**COMMENTS ON THE AMENDED ENVIRONMENTAL IMPACT STATEMENT FOR THE UPPER SOUTH CREEK
ADVANCED WATER RECYCLING CENTRE PROJECT**

Thank you for the opportunity to provide comment on the amended Environmental Impact Statement (EIS) for the Upper South Creek Advanced Water Recycling Centre Project (the Project), exhibited from 23 March 2022 to 5 April 2022.

Figure 4-11 Environmental flows pipeline alignment

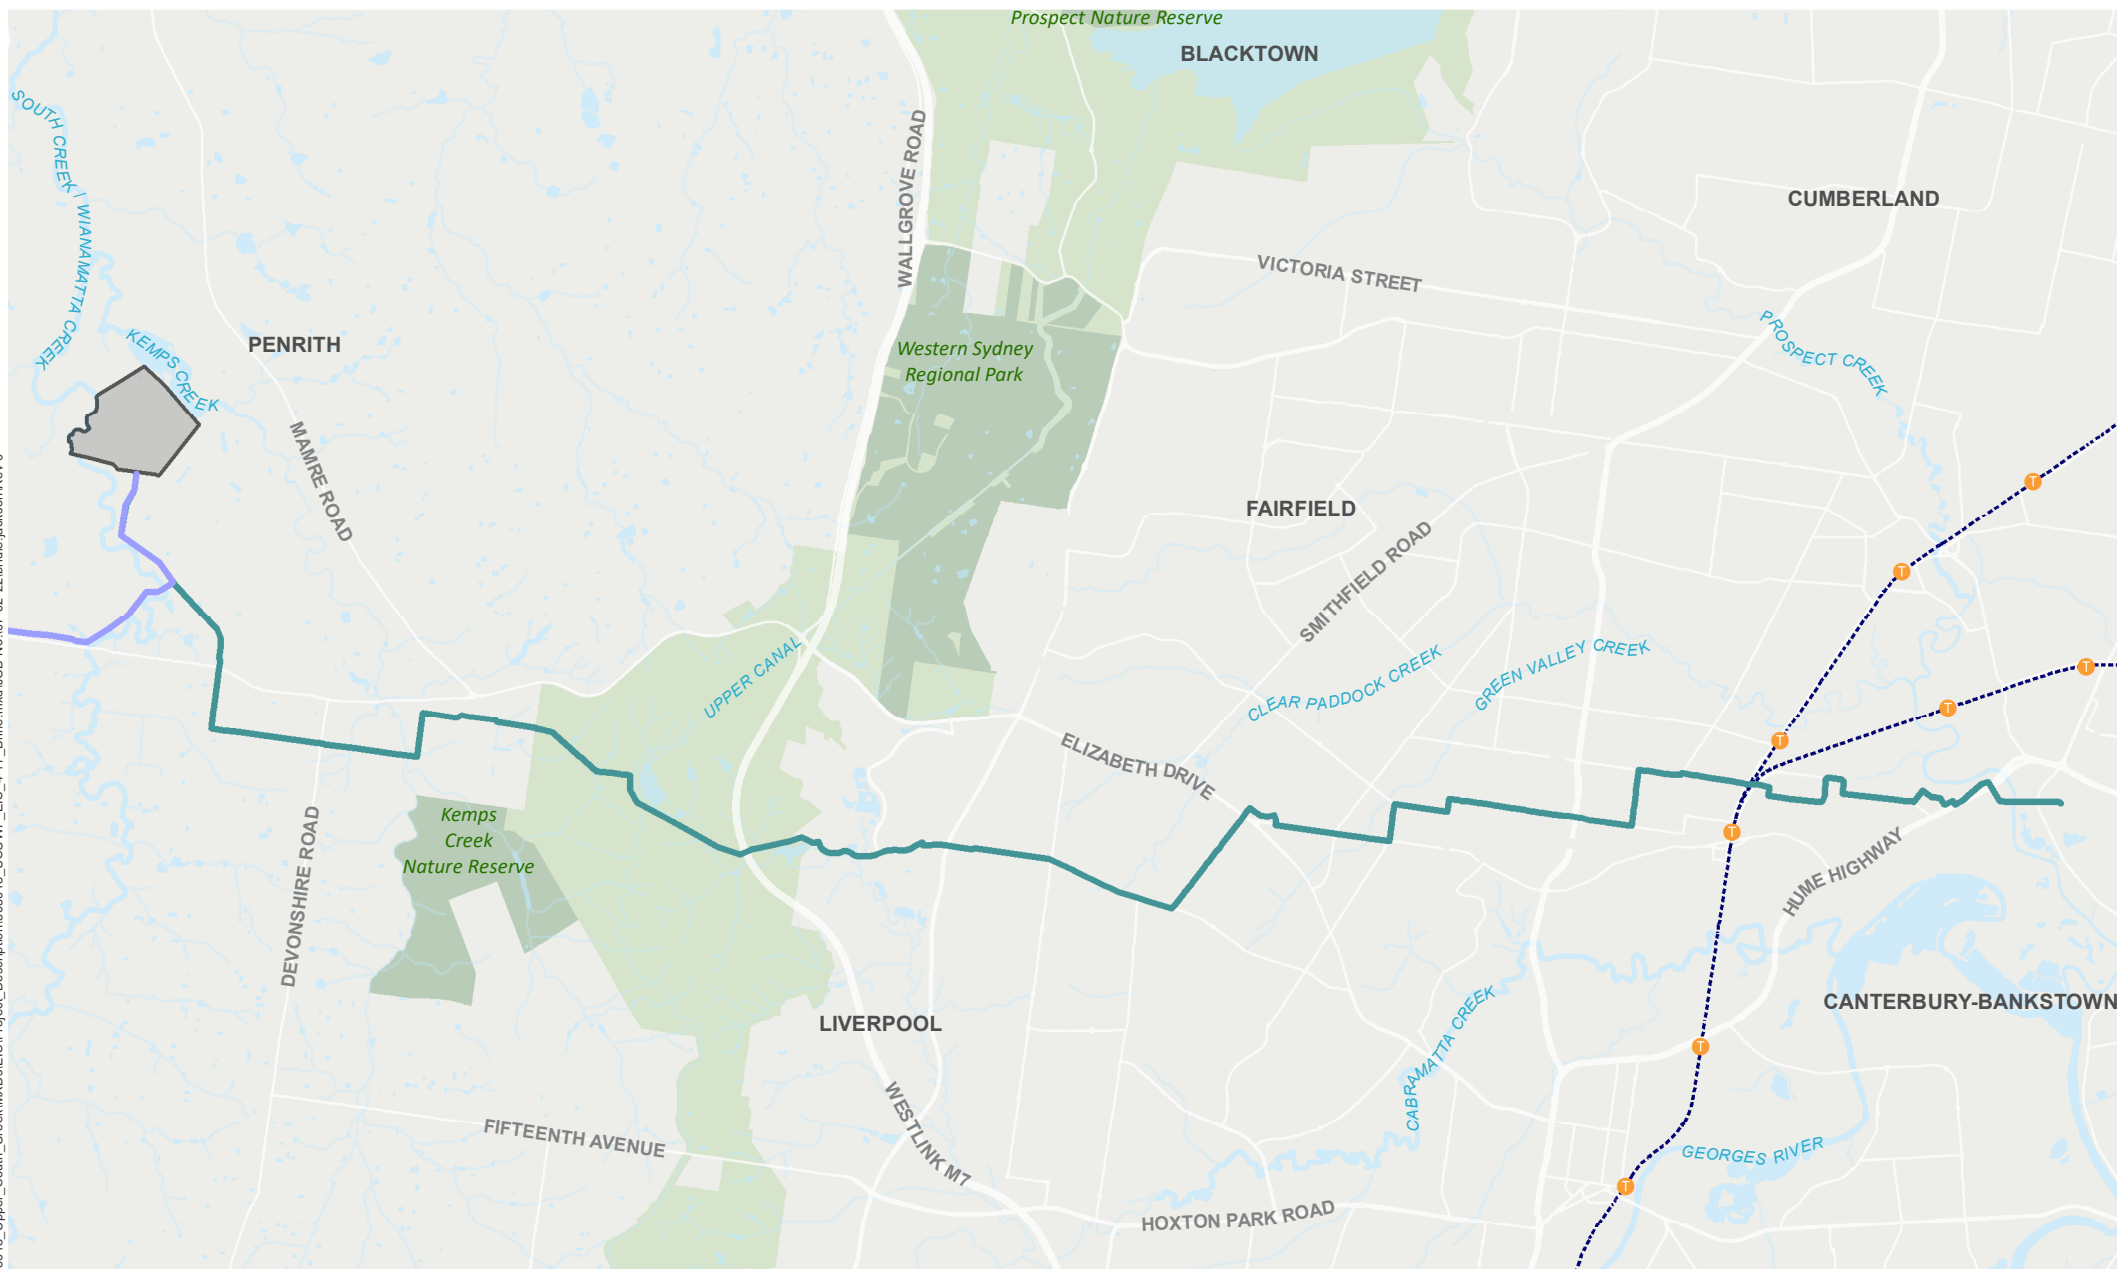
It is also noted in the amended project description that the environmental flows pipeline might not go ahead (further detailed in Section 3.5.1 of the EIS). This is a concern for water quality within the Warragamba River between the base of the Dam and Wallacia Weir, which will be severely impacted should environmental flows cease in this area.
